6 November 2013

***Modification Request for the University of Sydney Abercrombie Precinct
Redevelopment: Application Number: MP07_0158 MOD 3***

I am a resident of Darlington and I am writing to you to make the following objections in relation to the above development modification request by the University of Sydney because the modifications would have an unacceptable adverse impact on the amenity of nearby residents.

Title
Scale
Date
Number
0 2 4
10 20m
Ground Floor Plan
MARK UP SET
1:200@A1
11.10.13
4001_DA02-D
© copyright nettleton tribe partnership pty ltd

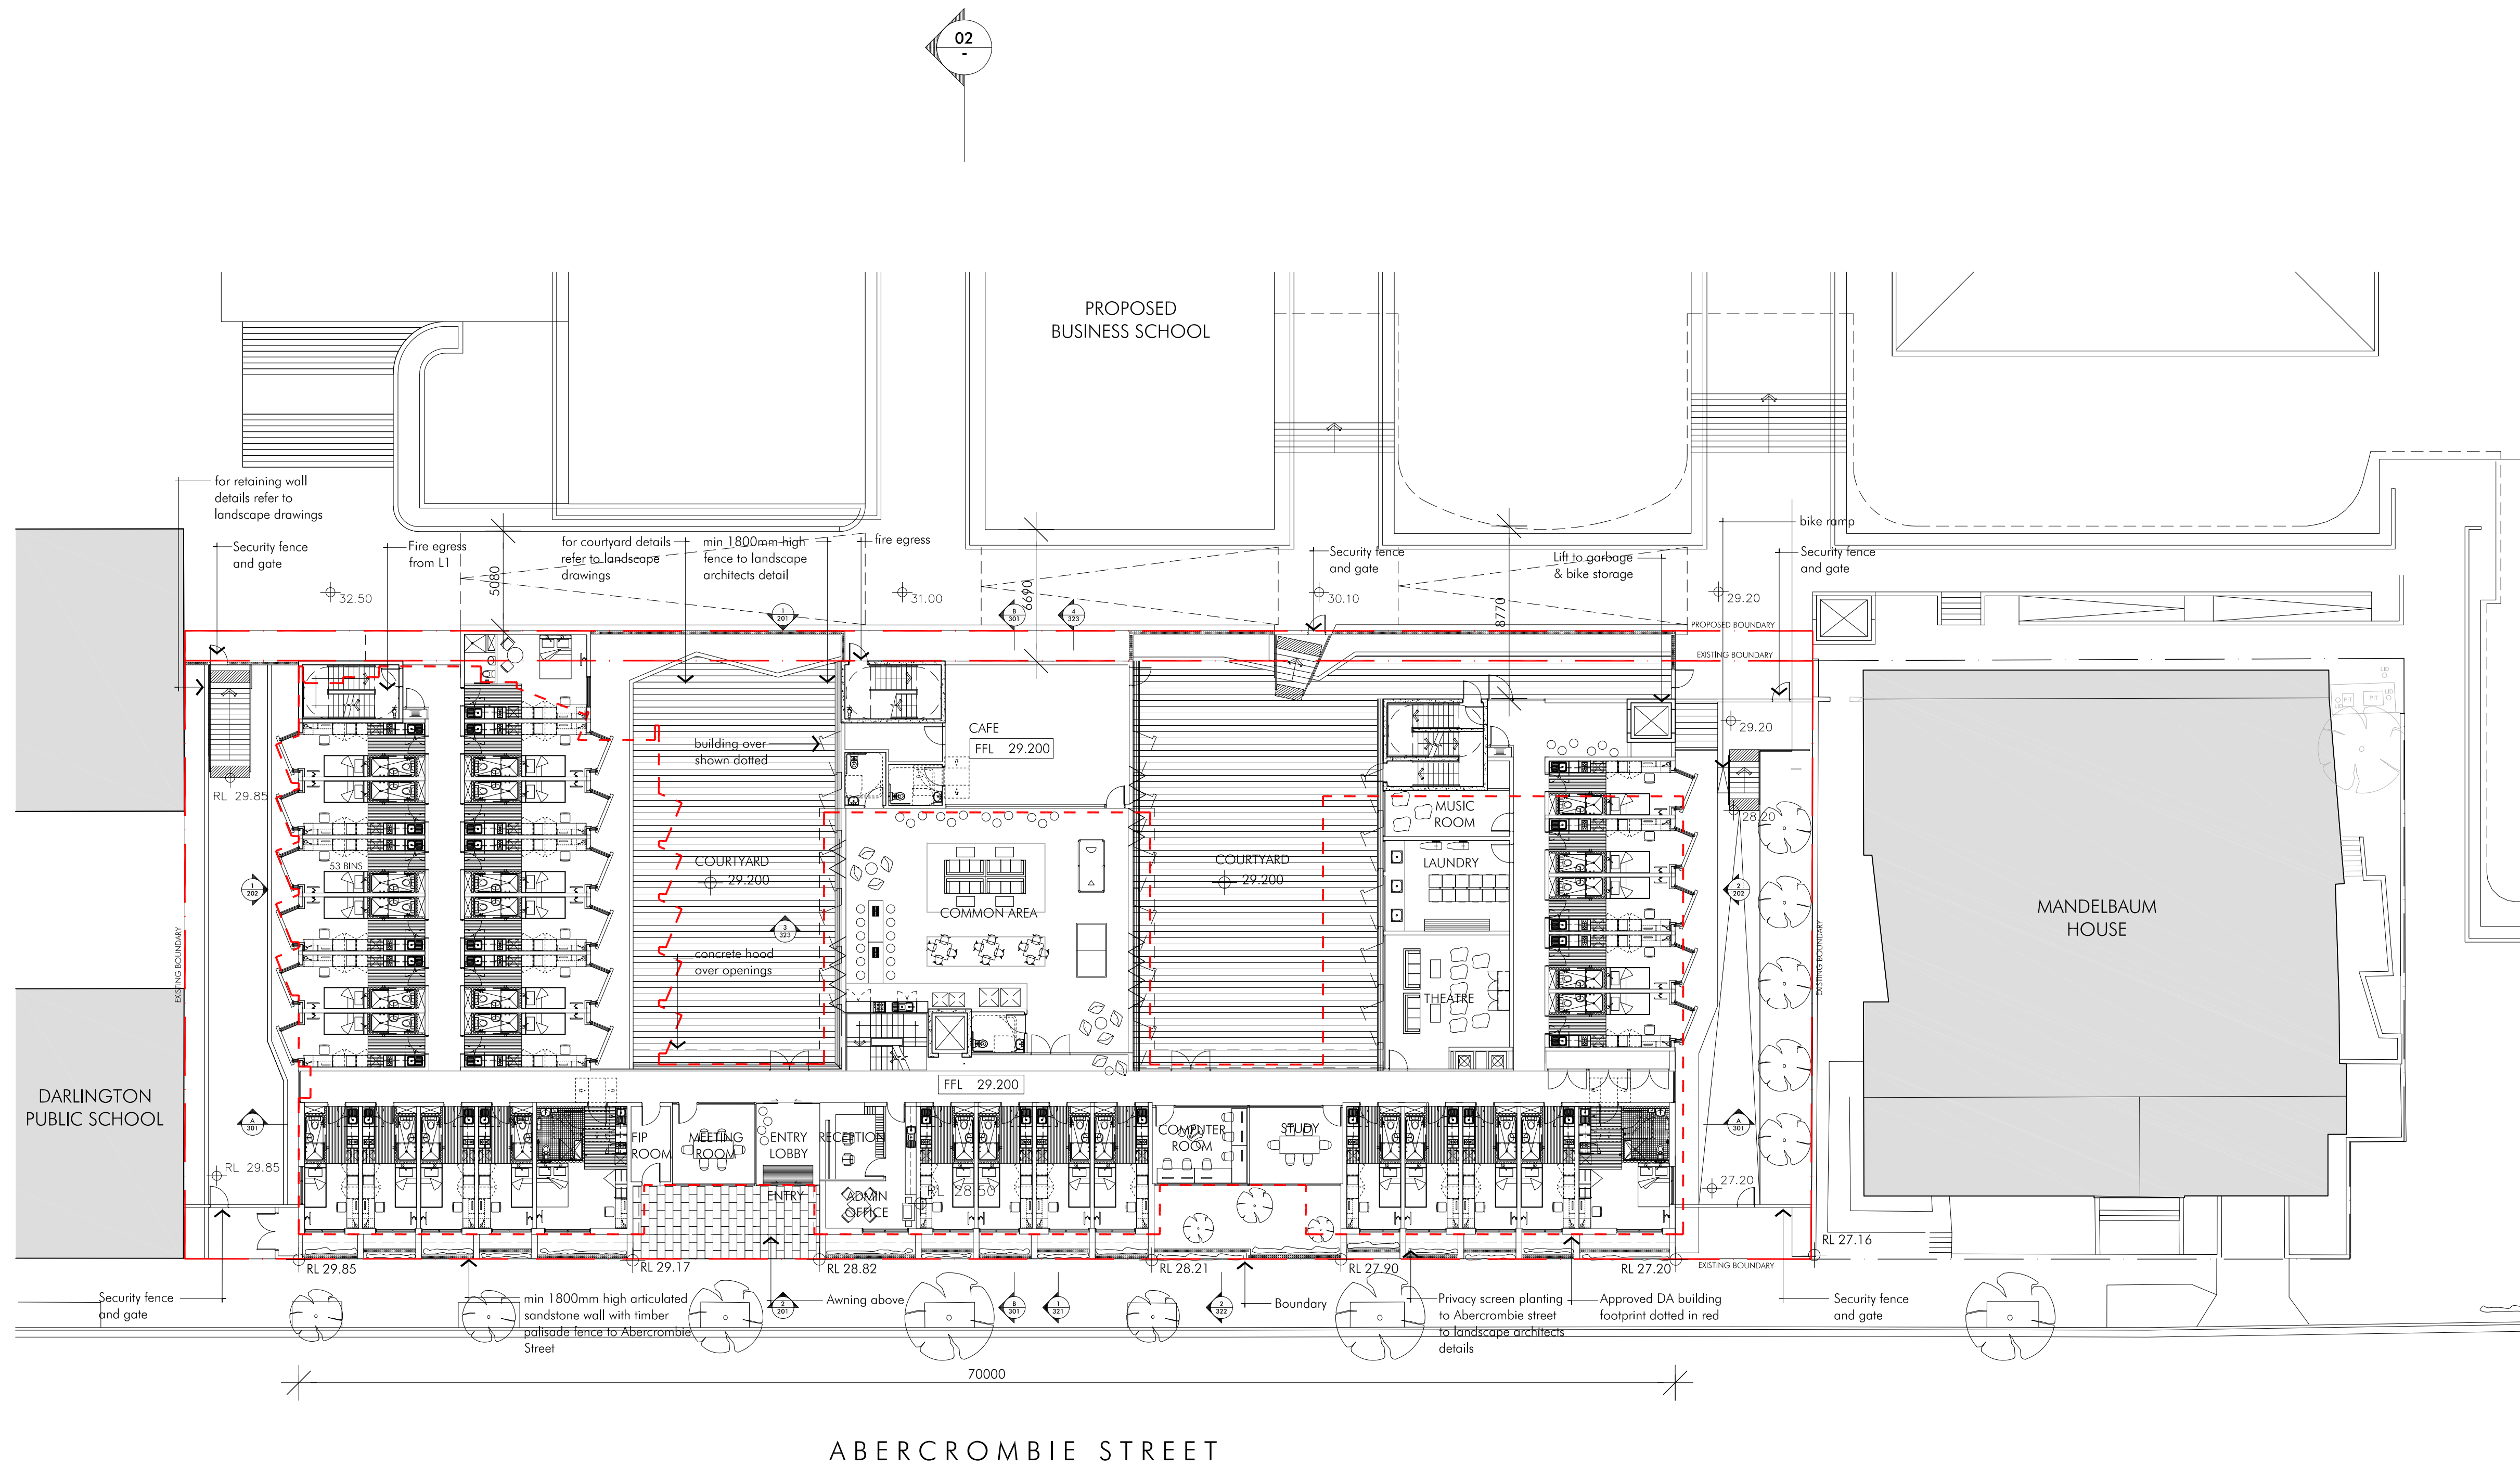
- The front of the Student Accommodation building should be built 2 metres back from the Abercrombie Street boundary. It should be set back from this boundary so that it is in line with Mandelbaum House as it was originally planned and presented to the community. The footprint of the buildings currently on the site, The Shepherd Centre and Boundary Lane Children's Centre, were built approximately 2 metres back from the Abercrombie Street boundary and align with Mandelbaum house. Therefore, the front footprint of the proposed Student Accommodation building should be the same as those buildings occupying the site at present and not be built up to the Abercrombie street boundary.

- The facade of the proposed Student Accommodation building does not reflect the heritage appearance of the Victorian terraces on Abercrombie Street as Mandelbaum House does. Therefore, it should be set back to allow for extensive vegetation and trees to be planted in front of the building on Abercrombie Street to help preserve the heritage streetscape and improve both the aesthetics and the environment of the street.
